Reference No:	2024/62/93354/W
Site Address:	26, Moorside Avenue, Crosland Moor, Huddersfield, HD4 5BH
Description:	Erection of front porch and dormer
Recommending Officer:	Molly Storer

HOUSEHOLDER DELEGATED REPORT

Application Number	2024/93354
Location	26, Moorside Avenue, Crosland Moor, Huddersfield, HD4 5BH
Proposal	Erection of front porch and dormer
Publicity end date	14 th January 2025
Number of representations received	None received
Kirklees Local Plan Allocation/Designation	Unallocated
Extension to Time (EoT)	Yes – 31 st January 2025
Recommendation	Conditional Full Permission

Proposed Floor Plans

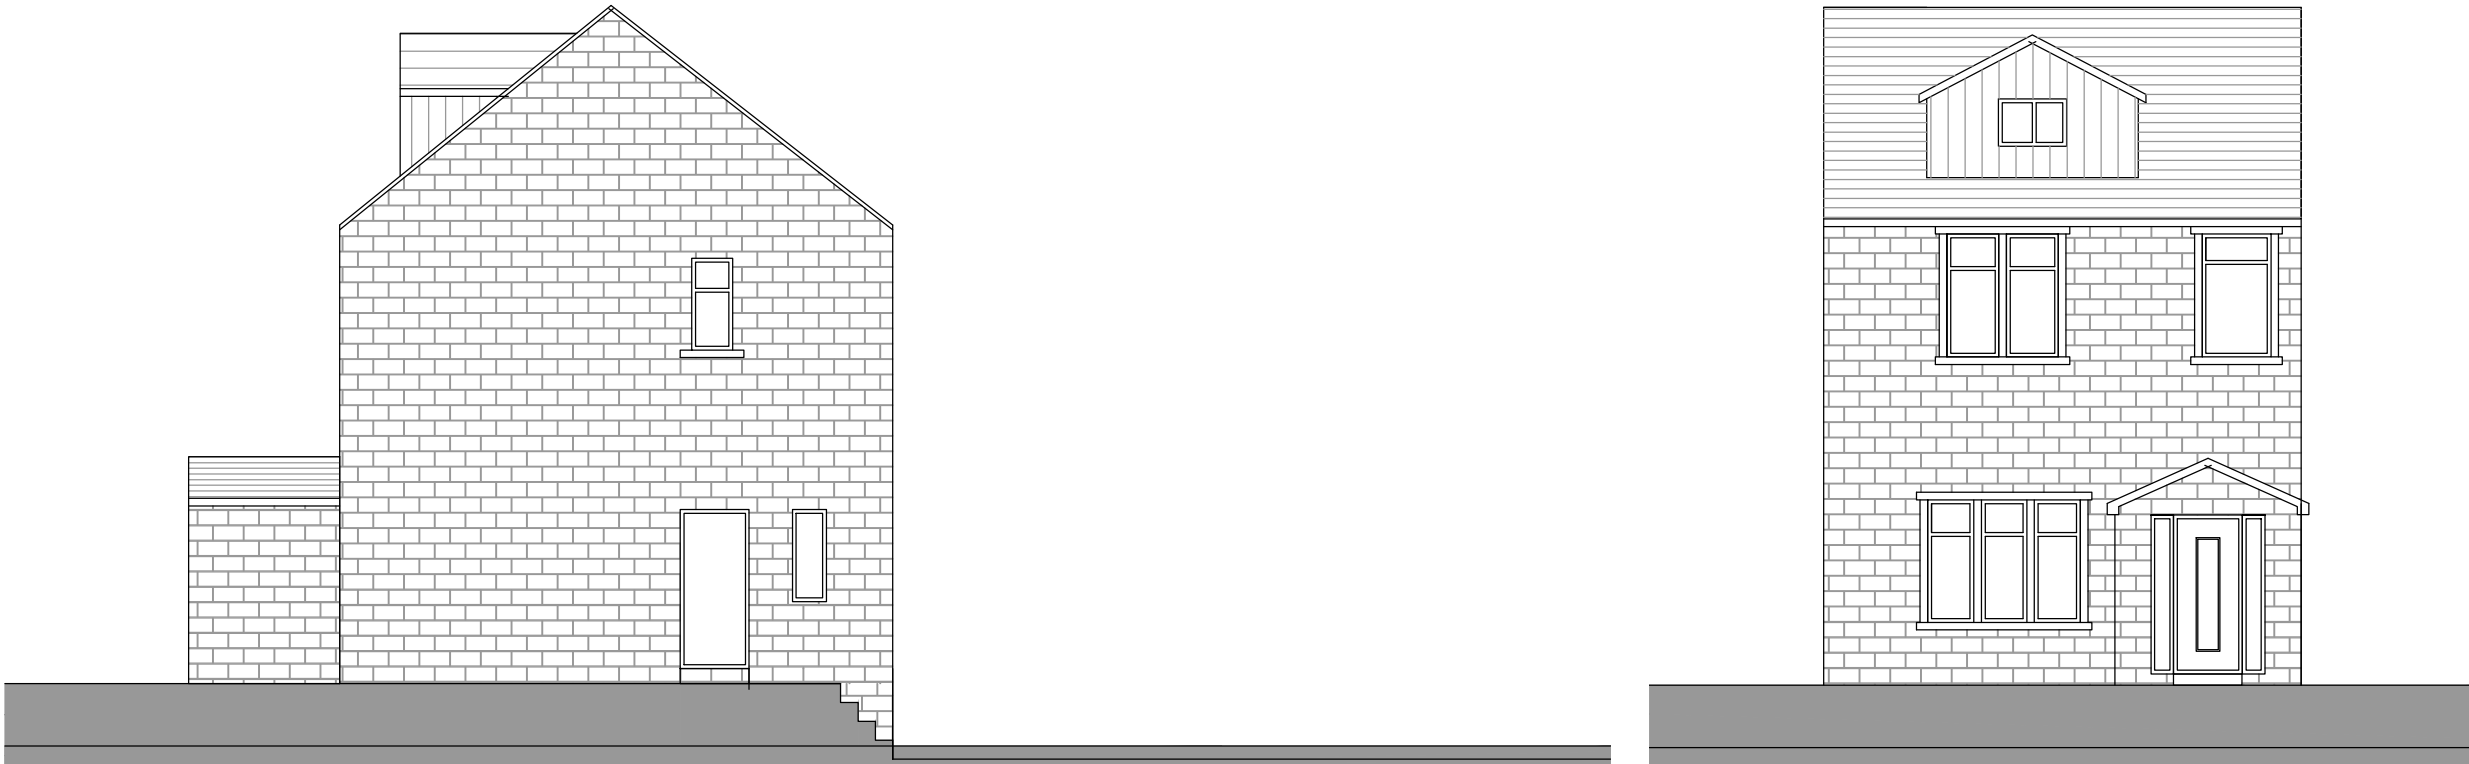
The dormer would be located to the front of the property of the south elevation. The measurements of the front dormer are as follows:

- 2.8 metre width
- 2.3 metre projection
- 1 metre to the eaves
- 1.7 metre overall height with a gable roof

The porch would be located on the same elevation with the below measurements:

- 2.5 metre width
- 2 metre projection
- 2.2 metre to the eaves
- 2.7 metre overall height with a gable roof

grant of permission which requires that the front of the dormer and dormer cheeks are tile hung to match the existing roof.	
not dominate the roof or project above the ridge of the house	It is considered that the front dormer would not dominate the roof or project above the ridge of the house and is small in scale. – it is set well within the confines of the roof slope.	
be set below the ridgeline of the existing roof and within the roof plane	Yes.	
be aligned with existing dormer windows on neighbouring properties in the same roof plane where relevant		The front dormer would have a single window which would not align with others on this elevation. However given the small scale nature of the dormer and due to windows on the ground and first floor not aligning it is considered that on balance this design is acceptable.

3. Notwithstanding the submitted plans and application form, the porch hereby approved shall be constructed from materials which in all respects match those used in the construction of the existing building and which shall thereafter be retained.

4. Notwithstanding the submitted plans and application form the external materials used in the construction of the roof, front elevation and cheeks of the dormer hereby approved shall be tiles that, in all respects match those used in the construction of the existing building and which shall thereafter be retained.
